NC DEPARTMENT OF  
**HEALTH AND  
HUMAN SERVICES**

October 17th, 2023

RE: McDonald's #32-0051  
1726 W. Cumberland St.  
Dunn, NC 28334

The letter acknowledges review of the remodel plan for the above reference establishment. The plans received on 07/25/2023, application and drawings, specifications, including e-mail correspondence and are approved with the following comments:

Sheet Number  
**P-101**

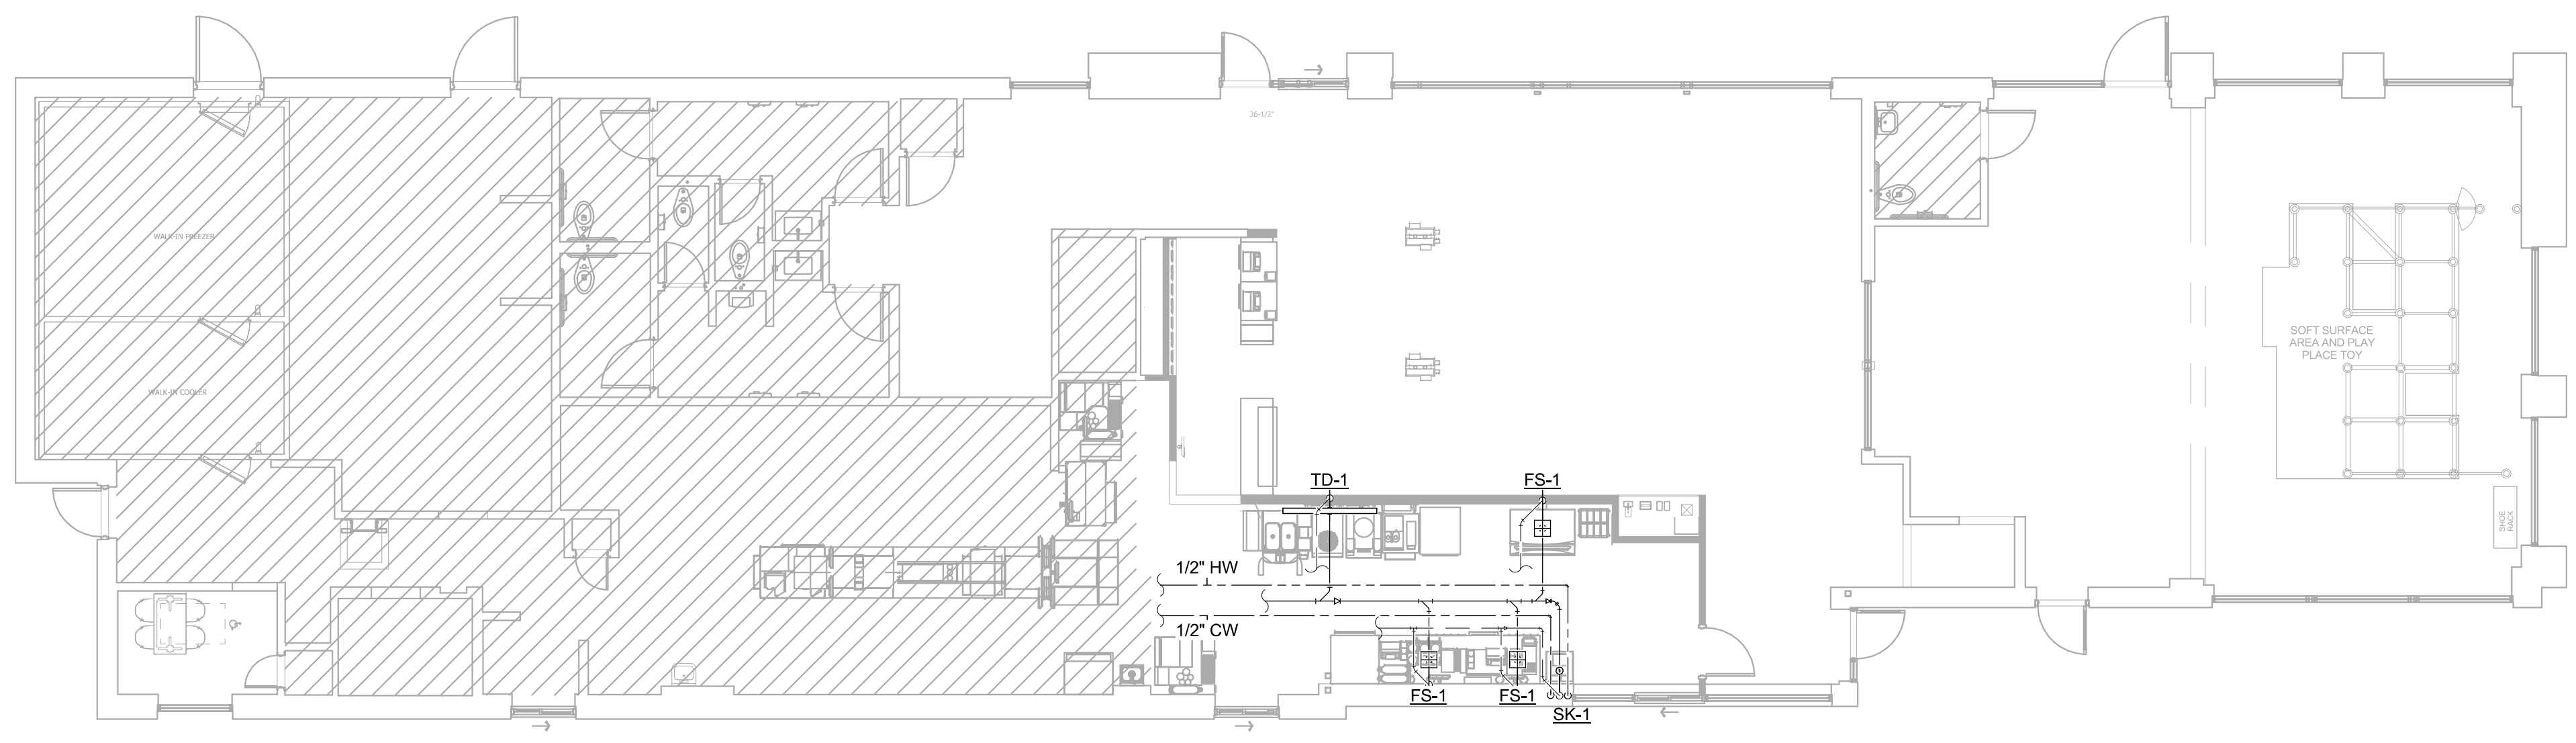
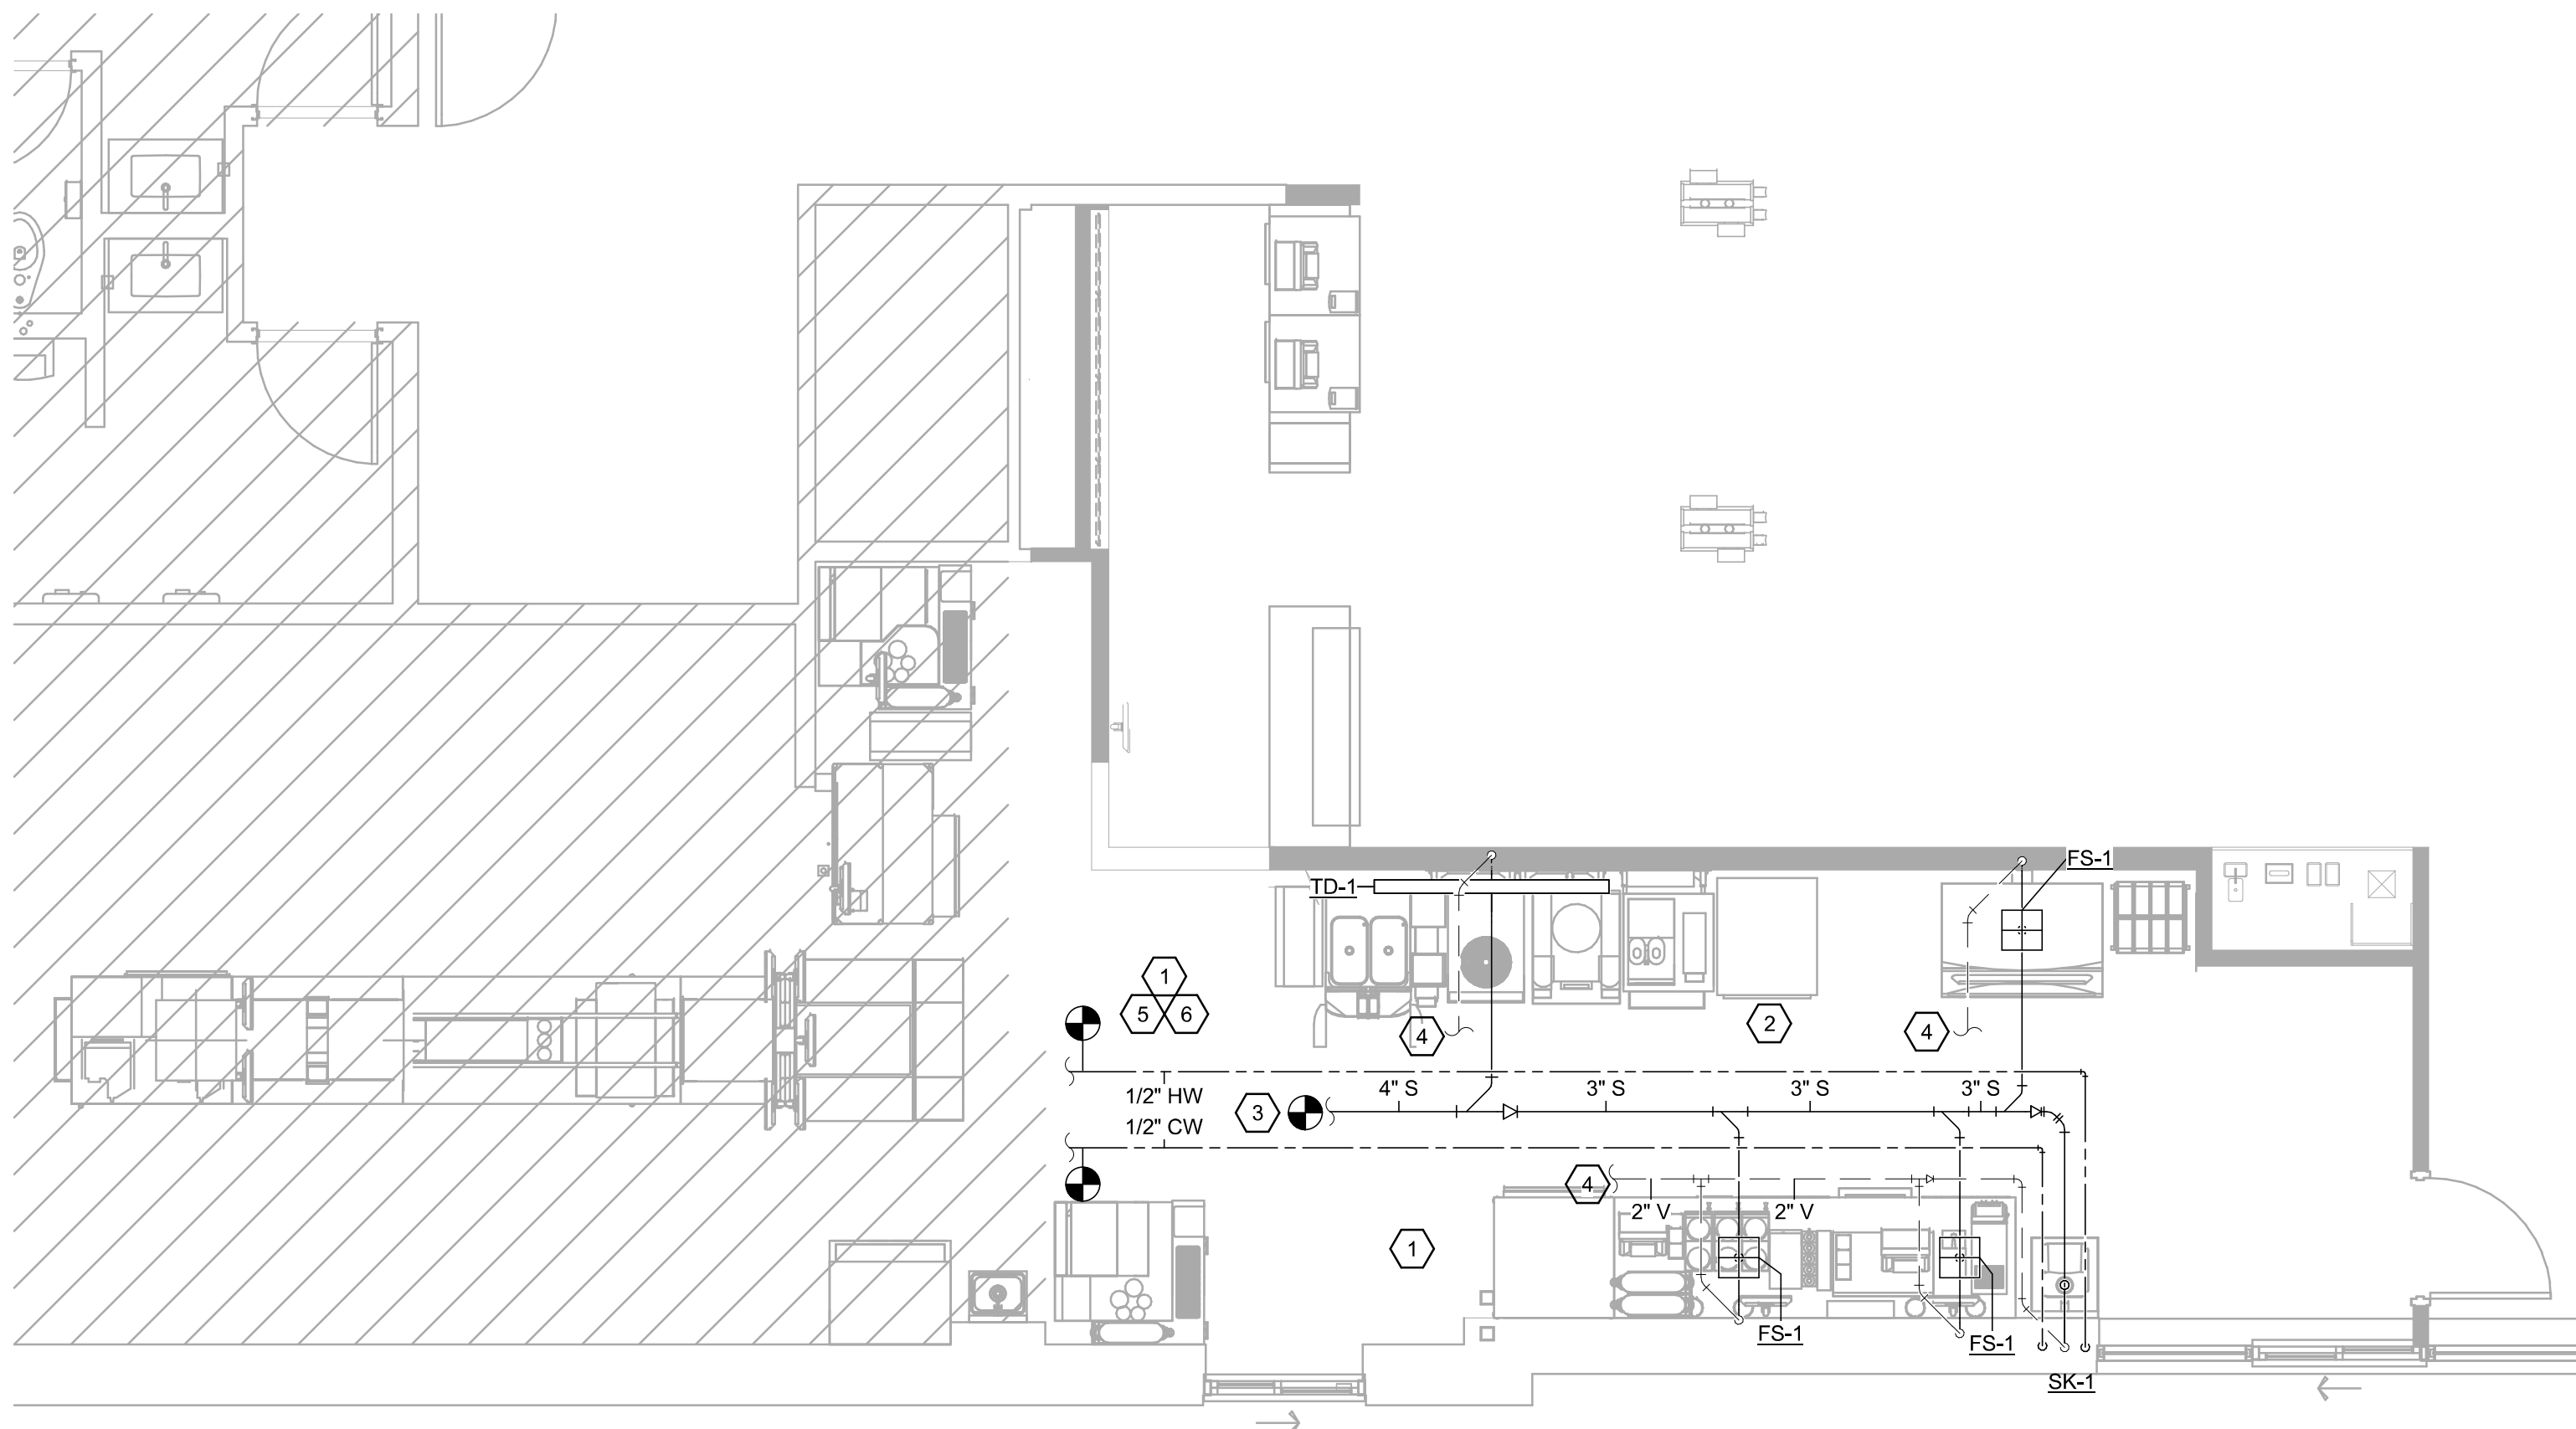
3. In addition, a new hand sink will be installed at this pick-up counter area, to supply convenient and accessible hand washing to all food preparation, and food dispensing areas and to meet NC Food Code requirements.
